WEST SUSSEX COUNTY COUNCIL CONSULTATION

TO:	Arun District Council FAO: K Welch
FROM:	WSSC – Highways Authority
DATE:	9 October 2025
LOCATION:	Pavement o/s Iceland 72-74 High Street Bognor Regis PO21 1SJ
SUBJECT:	BR/167/25/A Removal of existing BT Phone Kiosk and installation of 1 No new BT Street Hub, incorporating 2 No digital 1.905m internally illuminated LCD advert screens.
DATE OF SITE VISIT:	n/a
RECOMMENDATION:	Advice

Drawing Title
EXISTING AND PROPOSED
ELEVATIONS

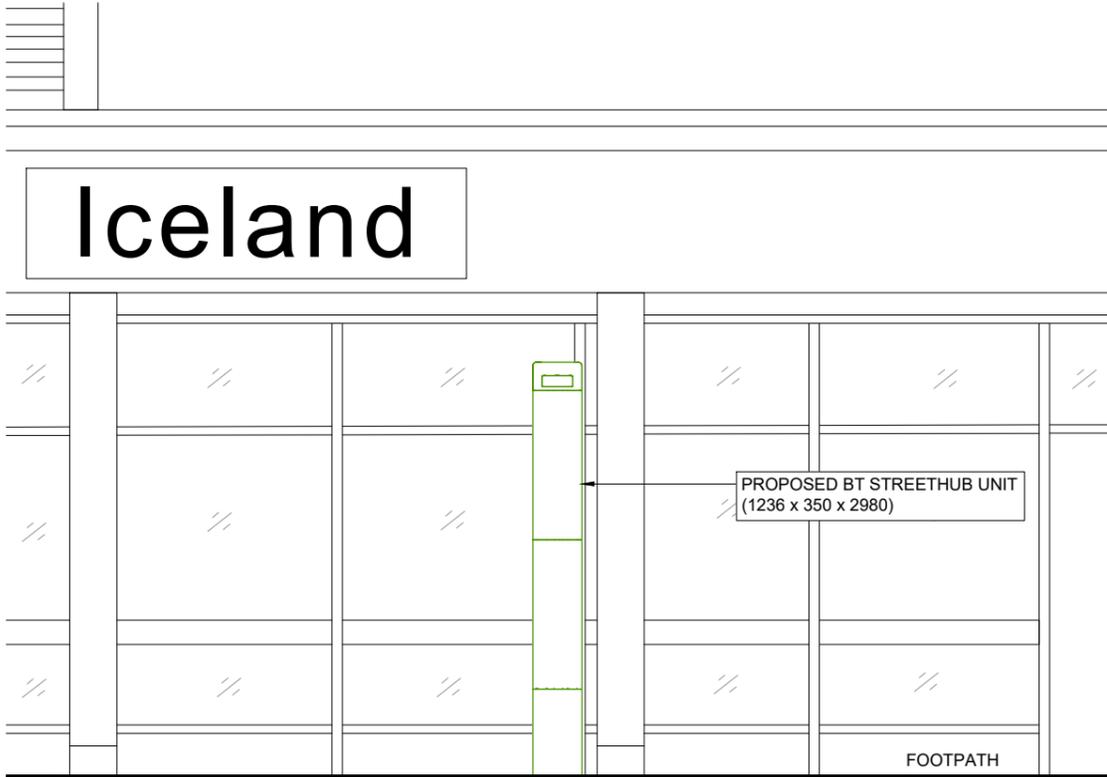
The proposed Street Hub will provide two digital 1.902m internally illuminated LCD advert screens. The Design and Access Statement indicates that the proposed advertisements will not contain moving images and changes between the advertisements will be instantaneous with no animated transitions. The maximum daytime luminance level would be 5000cd/m². The Design and Access Statement indicates that the applicant would be agreeable to a condition restricting the BT Street Hub to a maximum luminance level of 600cd/m² in the hours of darkness; however, in accordance with Table 10.4 of The Institute of Lighting Engineers' Professional Lighting Guide 05/23 "The Brightness of Illuminated Advertisements including Digital Displays" (2023), the maximum luminance level for an advertisement within the E4 environmental zone is 300cd/m².

Whilst the LHA would not raise any highway safety concerns to the principle of the proposed BT Street Hub, we would request that the applicant reduce the proposed luminance level within the hours of darkness to accord with the maximum luminance level for the location's environmental zone. The LHA consider that this could be dealt with via condition, however the LPA may wish to resolve this matter prior to determination.

2. The intensity of the illumination of the signs shall not exceed 300cd/sqm during the hours of darkness.

3. The intensity of the illumination of the signs shall not exceed 5000cd/sqm during daylight hours.
